DEVIATION REQUEST AND DECISION FORM

Project Name : Trinity Ranch Estates, Filing No. 1

A deviation from the standards of or in Section **2.6 Structure Design** of the Engineering Criteria Manual (ECM) is requested.

2.3.8.A Roadway Terminations - Cul-de-Sacs

TRINITY RANCH
EL PASO COUNTY, COLORADO
PRELIMINARY PLAN
OVERALL SITE PLAN

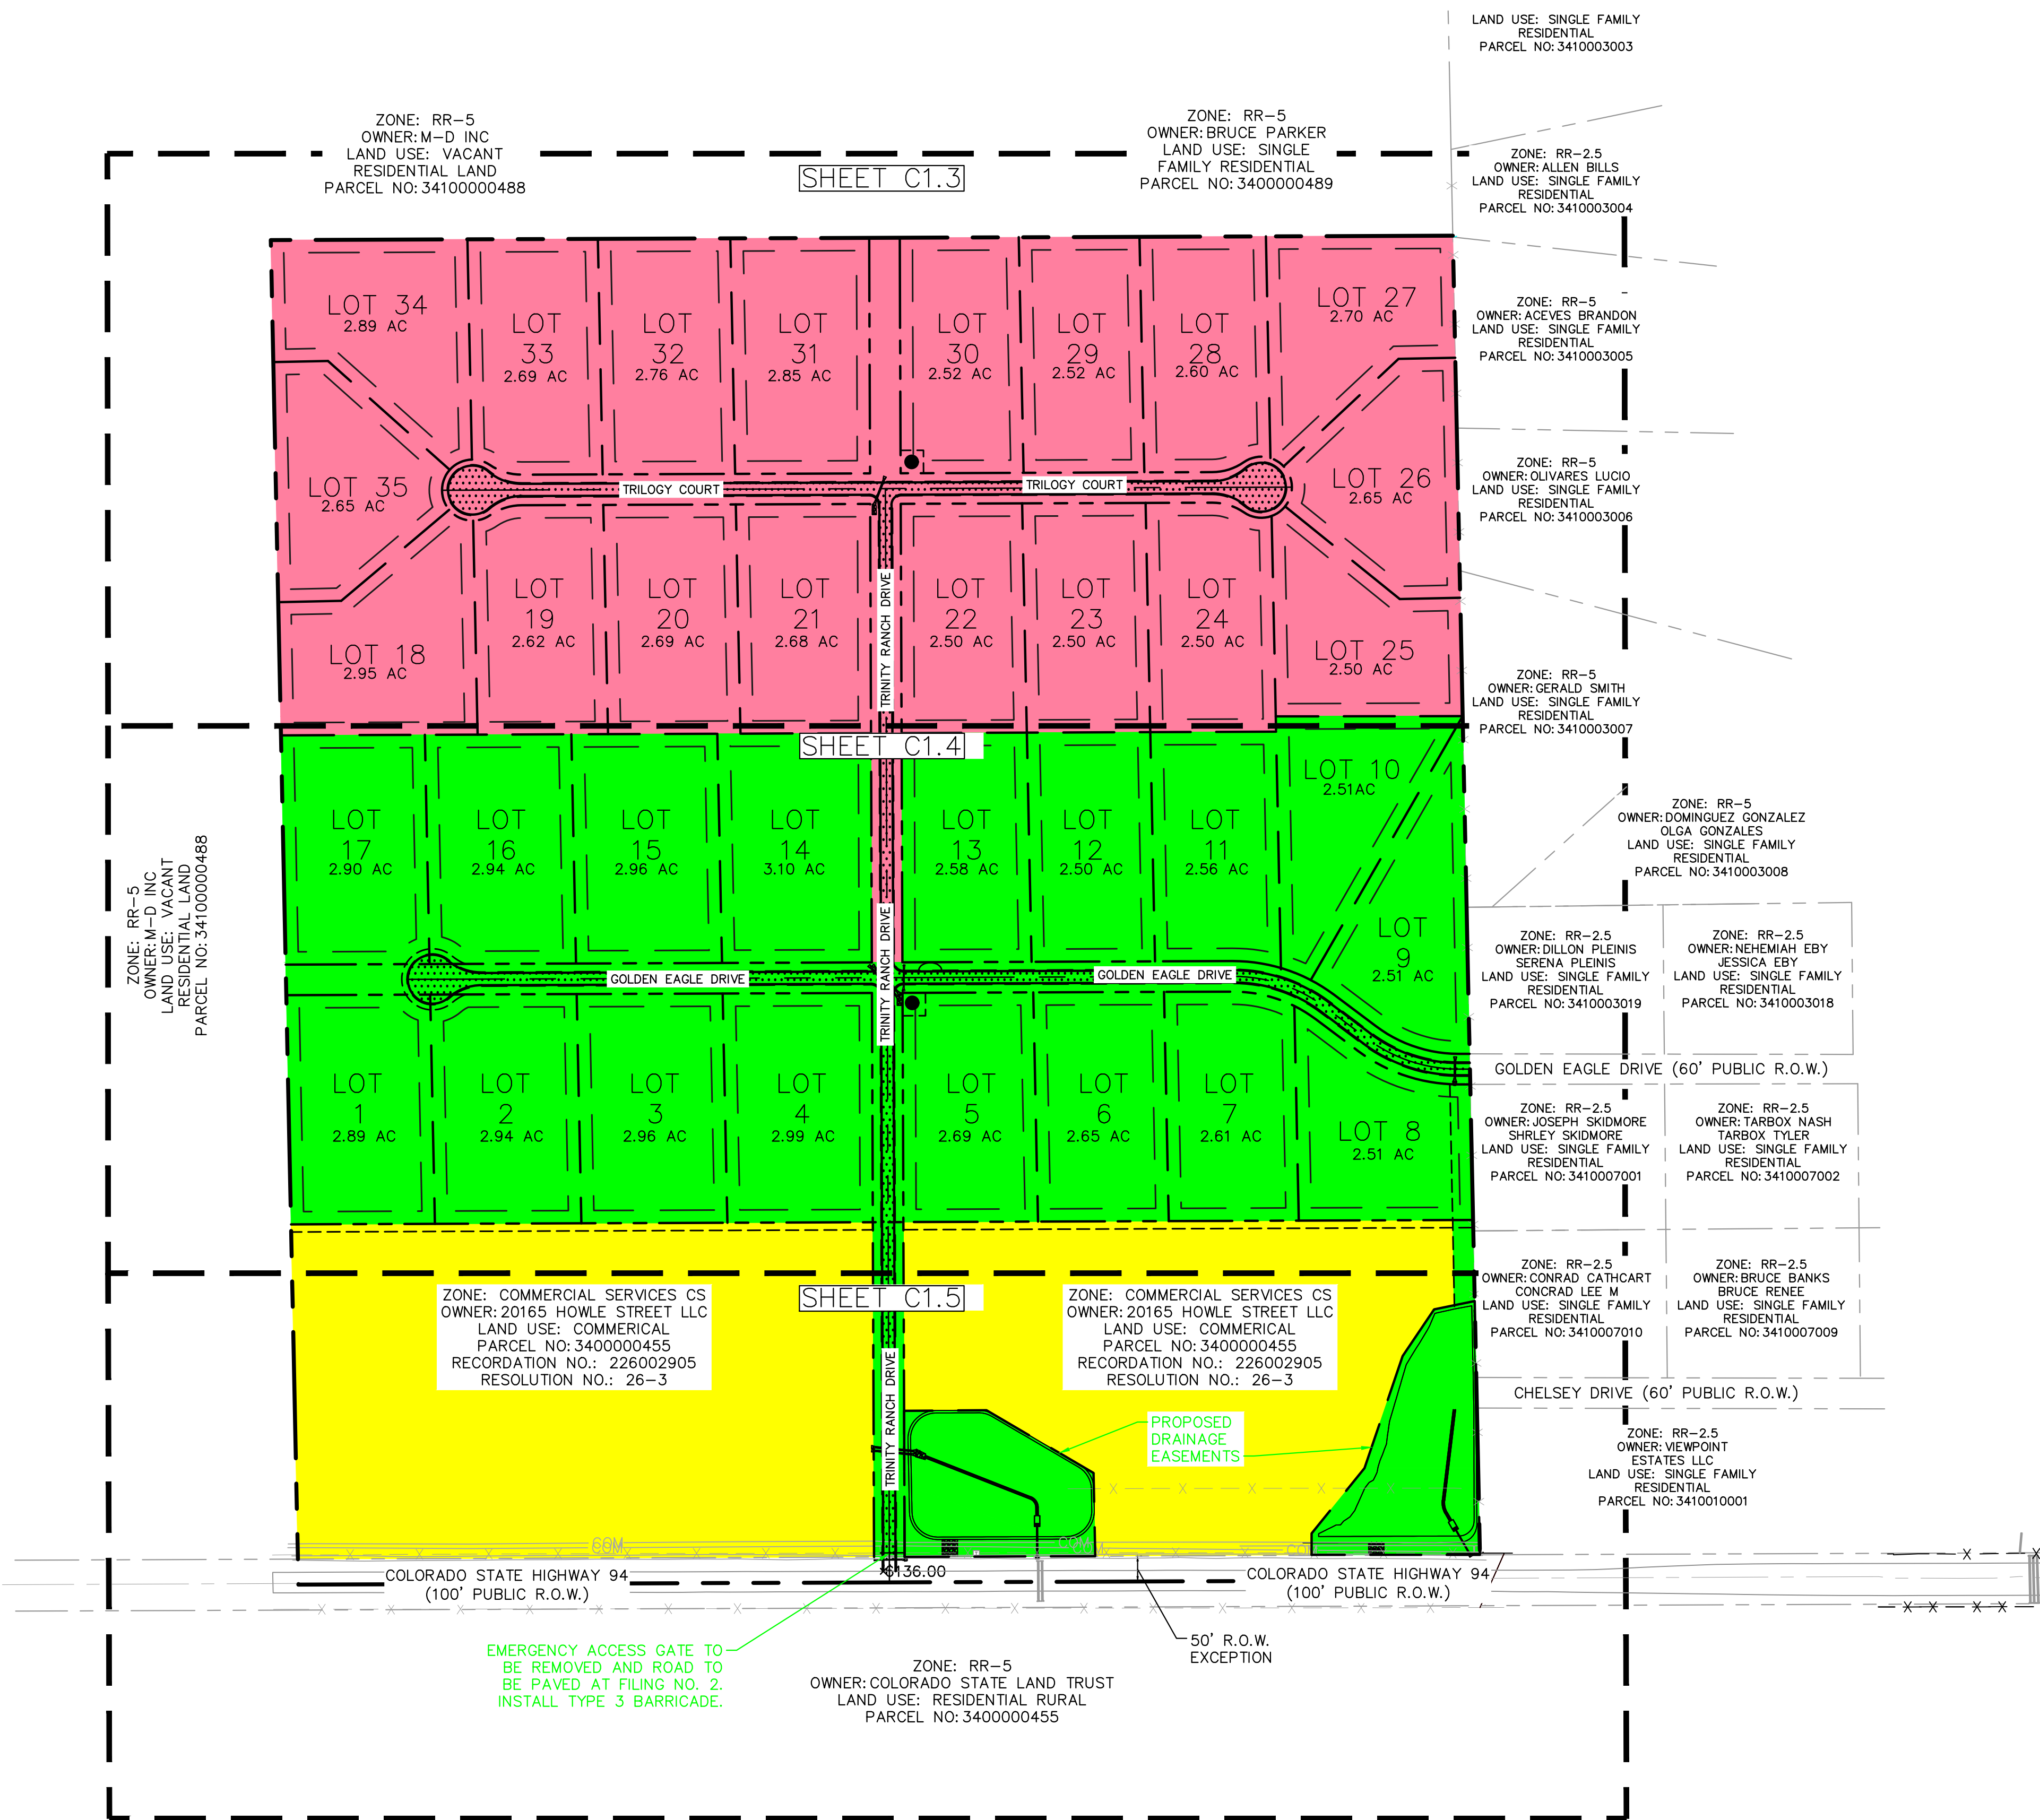
per ECm 2.3.8 this deviation will not be considered without an express endorsement from the fire district.

provide an exhibit of the proposed cul-de-sacs showing the length

CULVERT P4 PLAN AND PROFILE

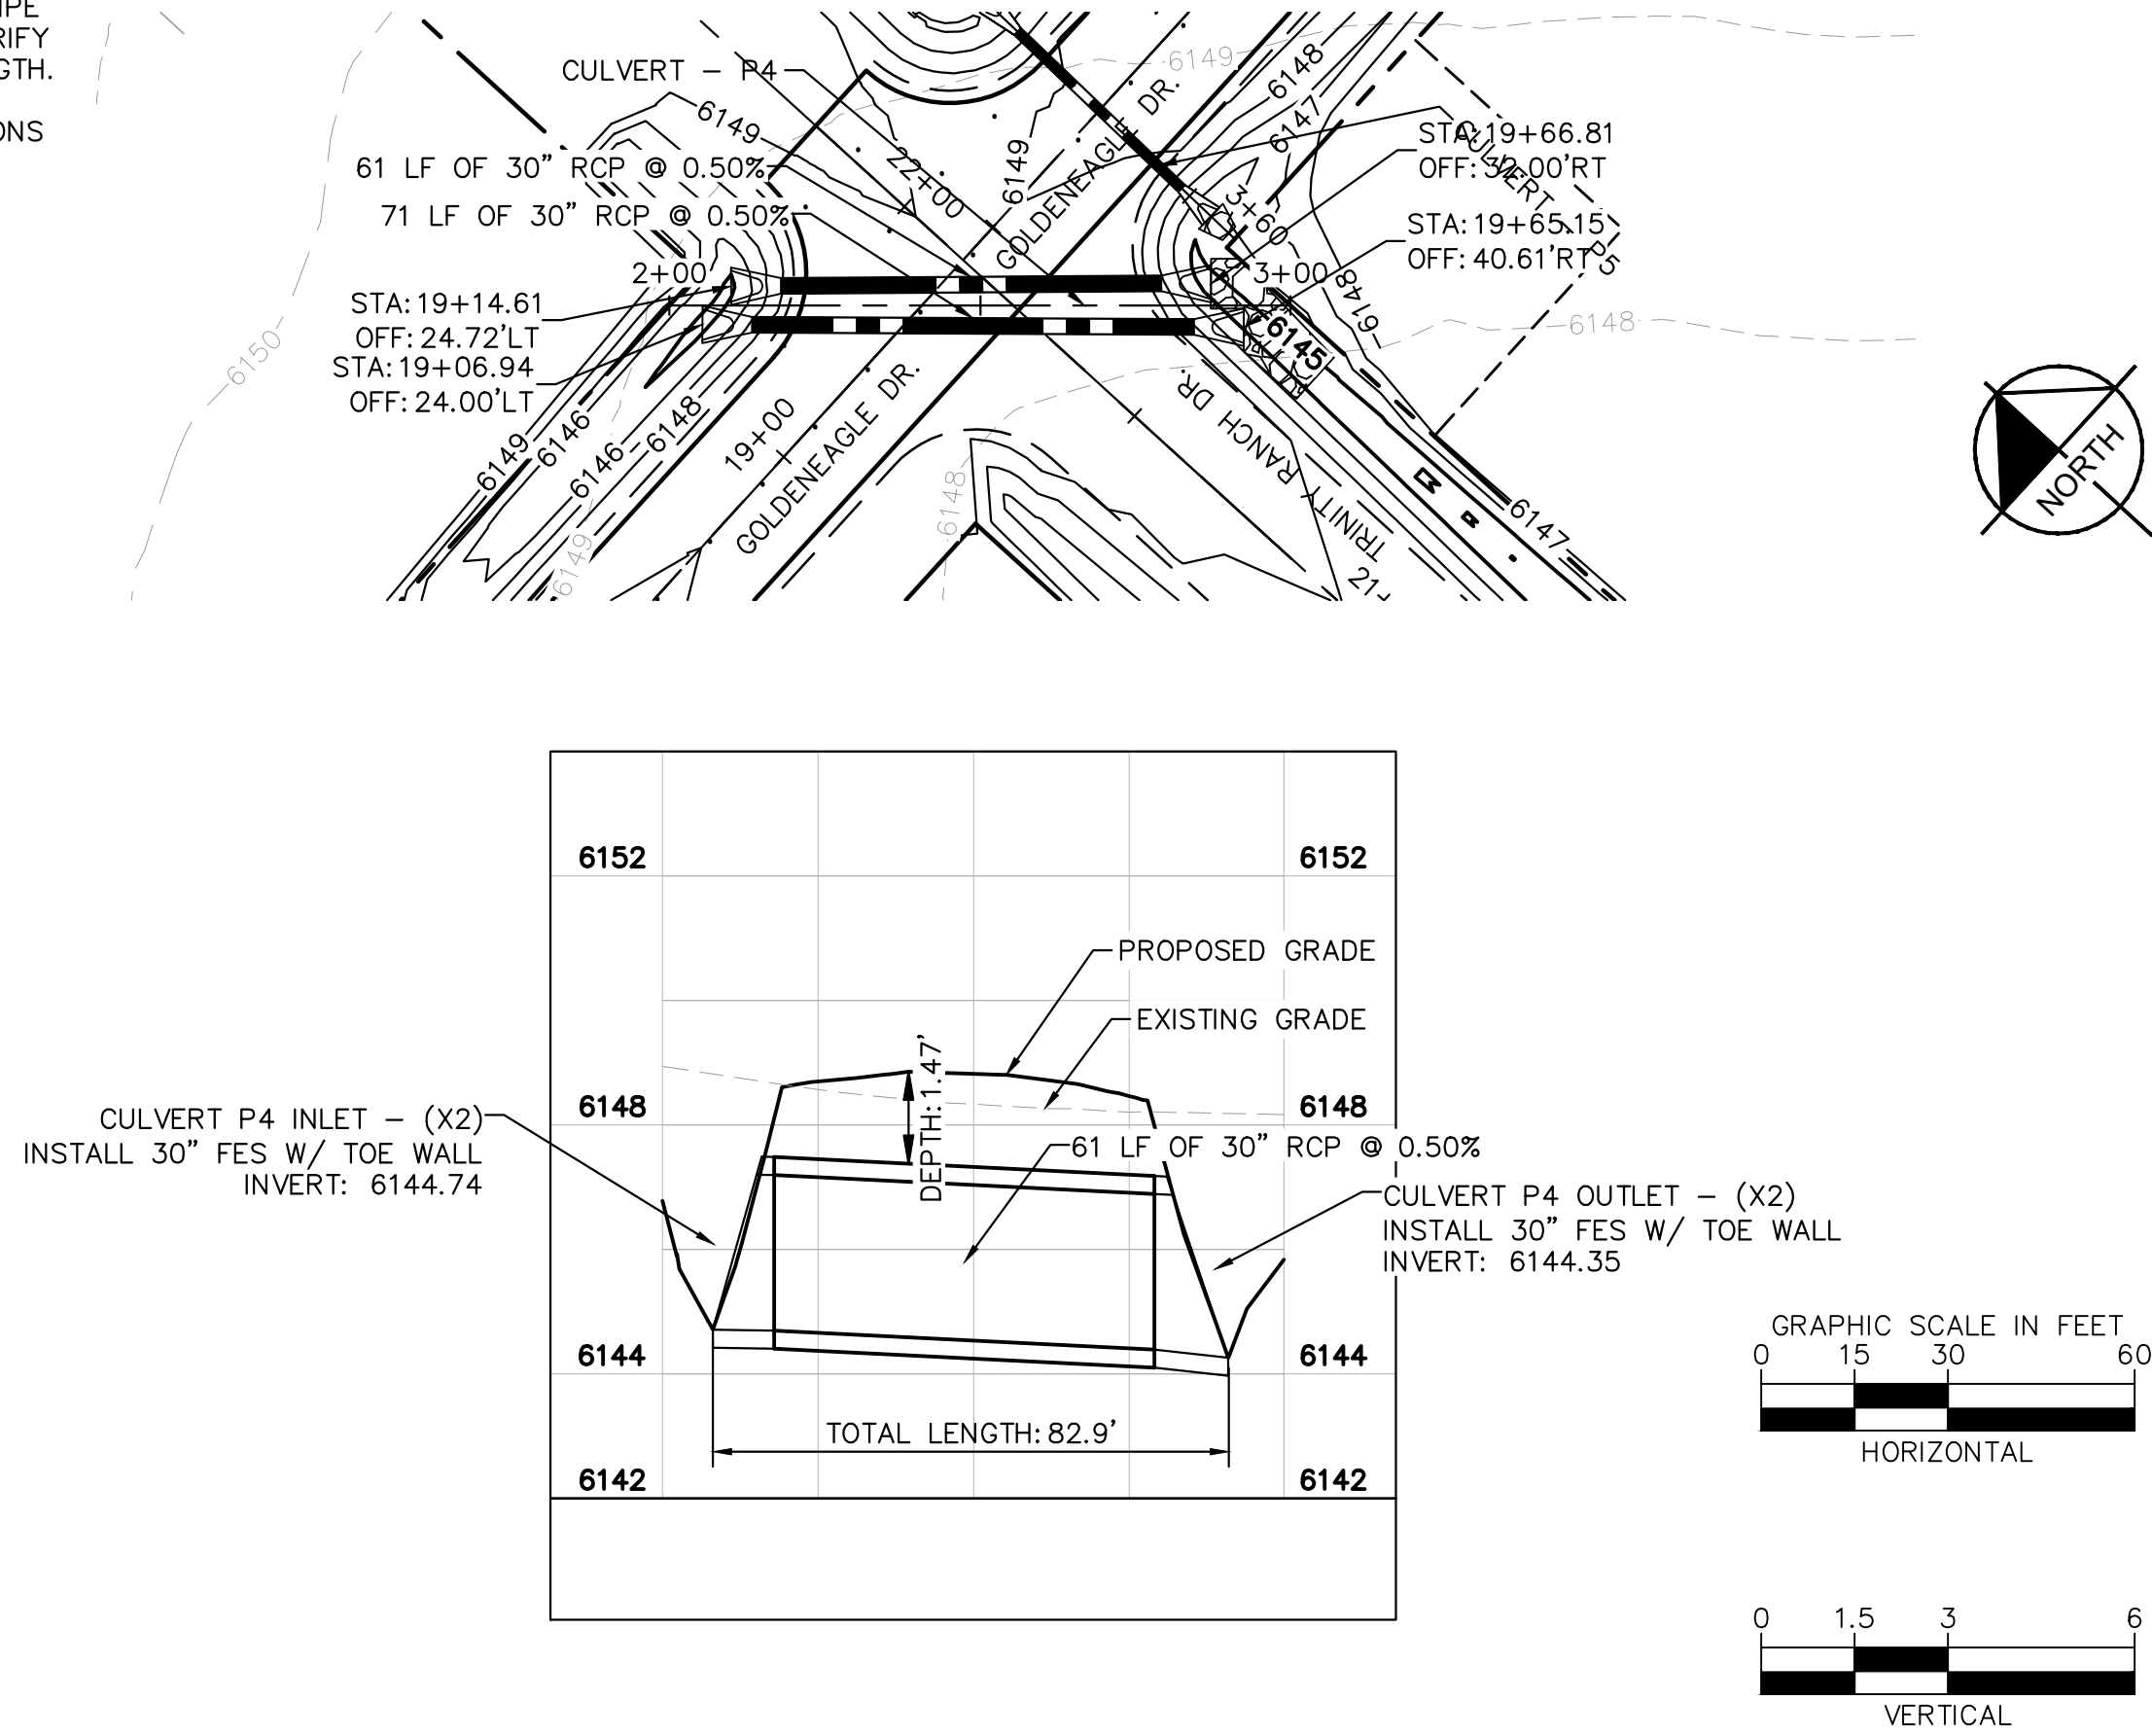
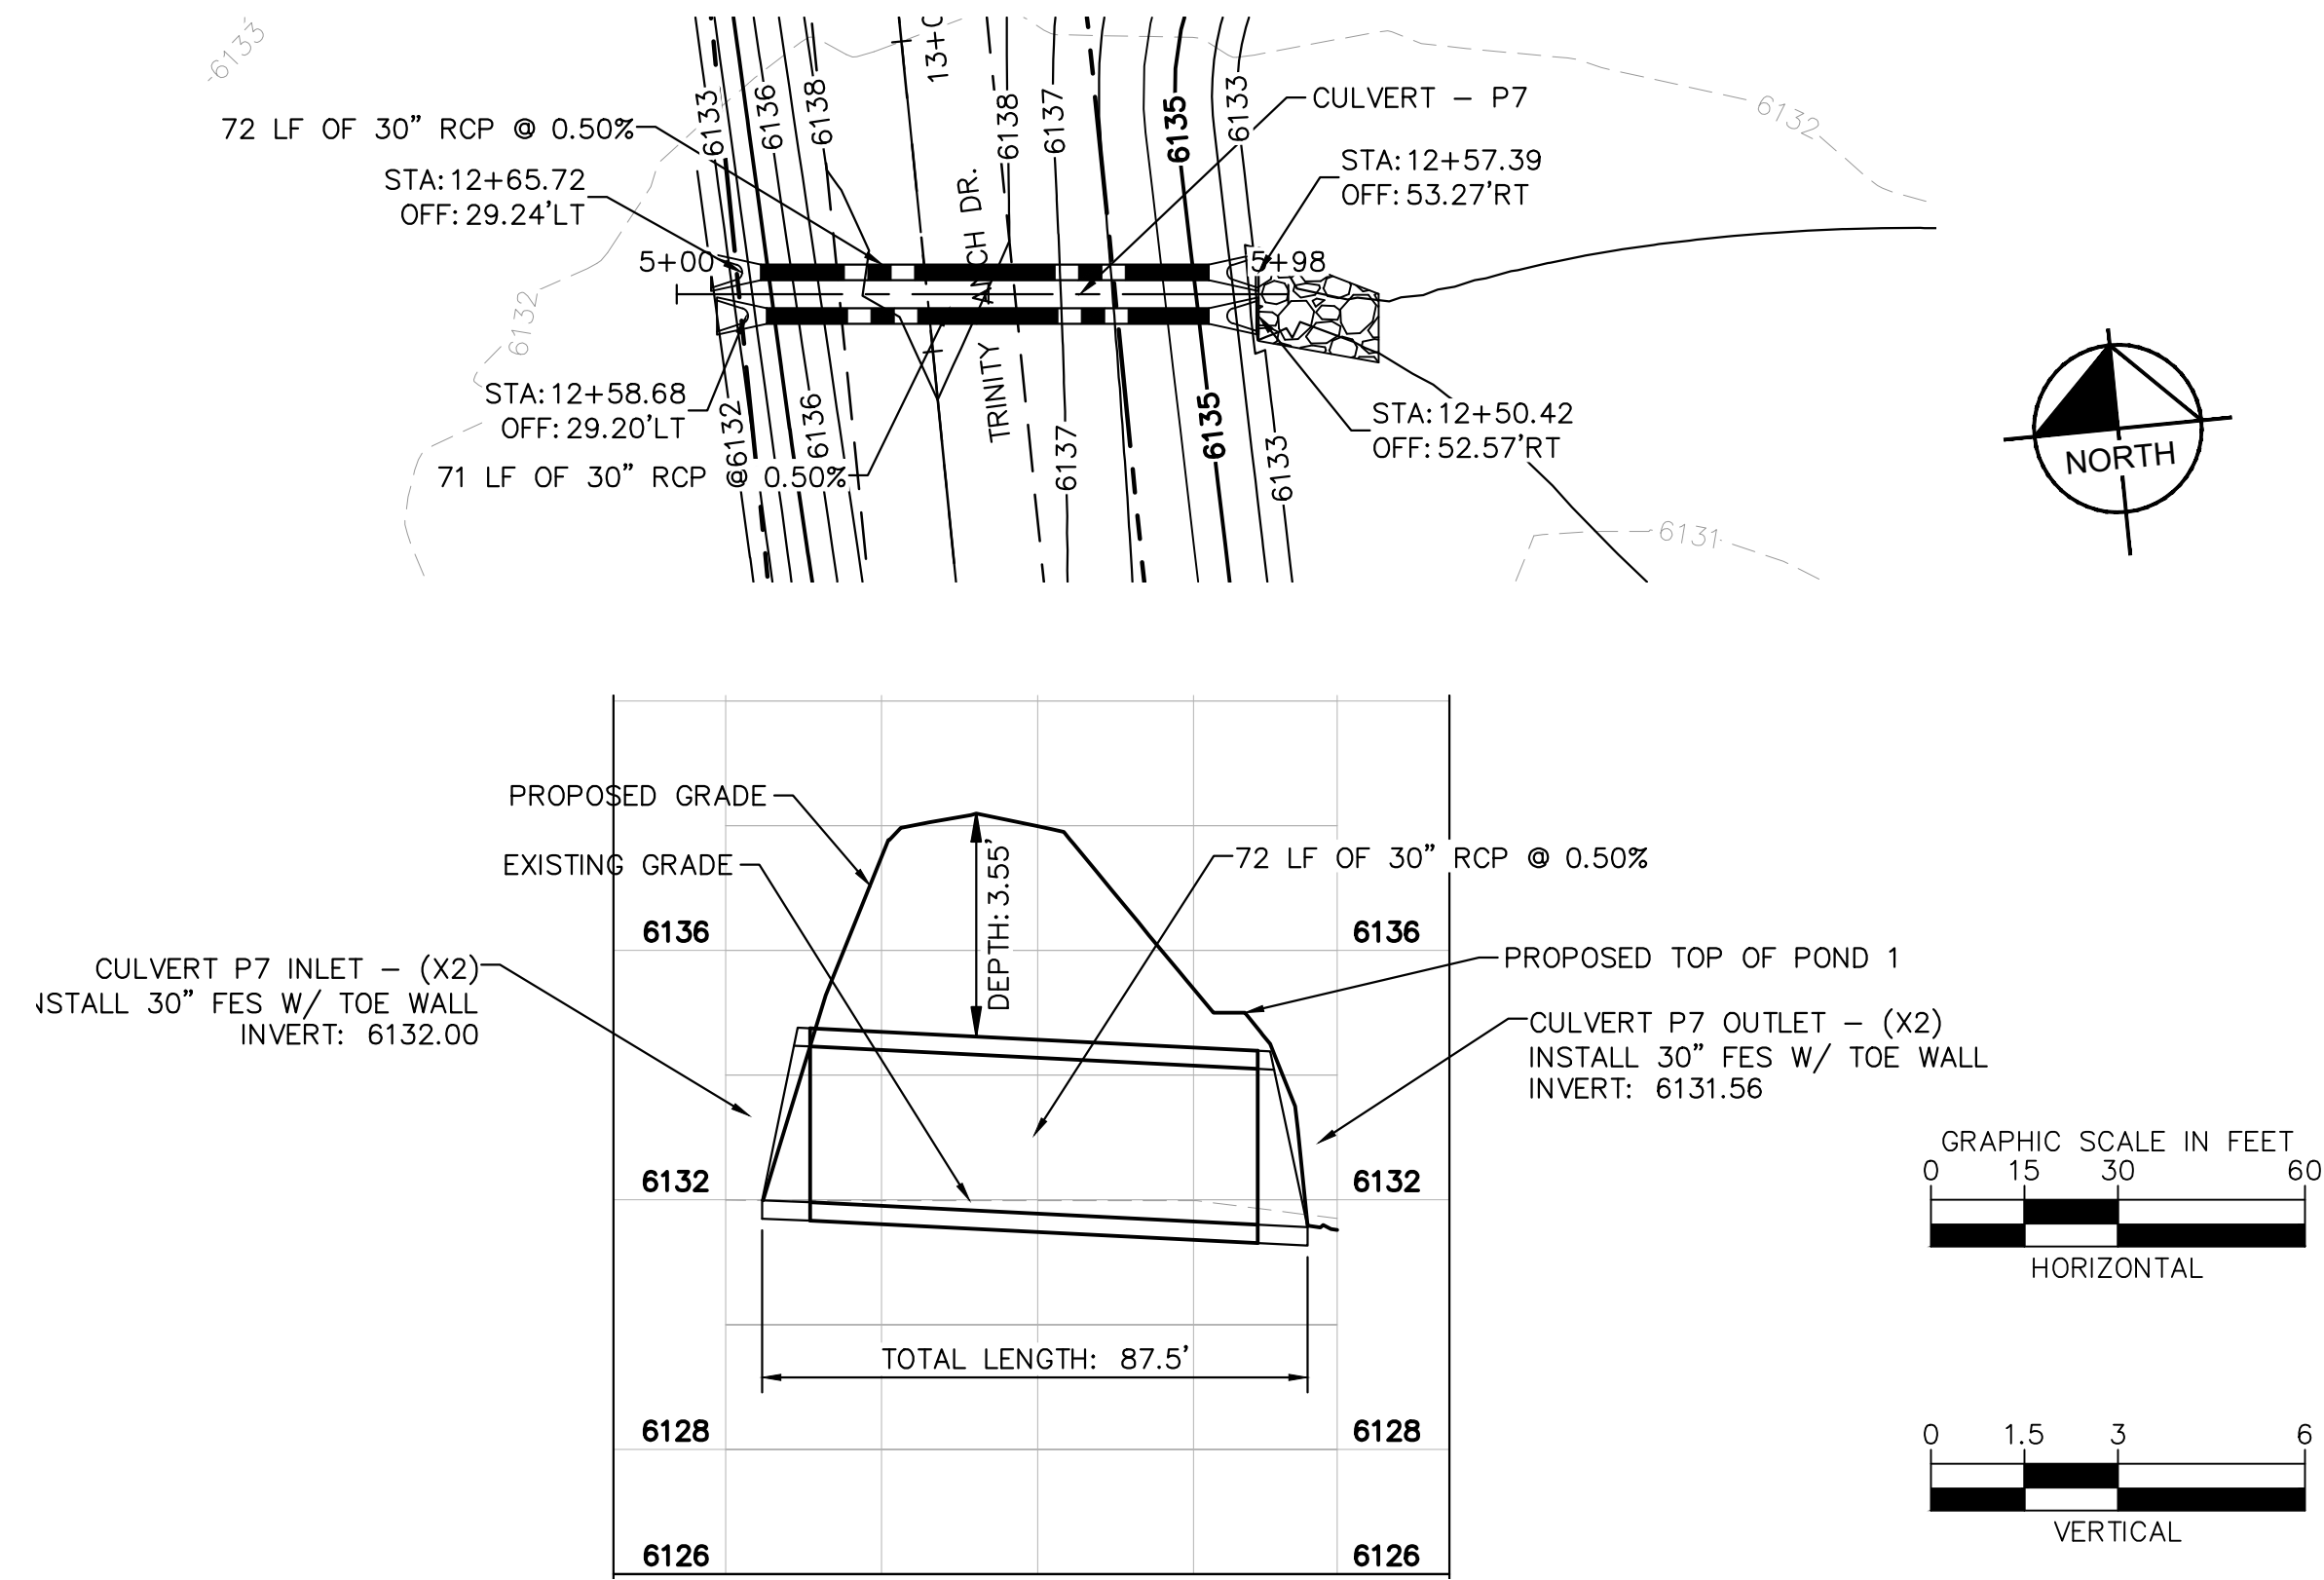
provide an exhibit
showing the proposed
culverts

A request allow for multiple pipe crossing (i.e. parallel culverts) for Culvert P4 and P7, double 30-inch RCP culverts to allow for the proposed roadway to cross over a shallow and wide natural drainageway.
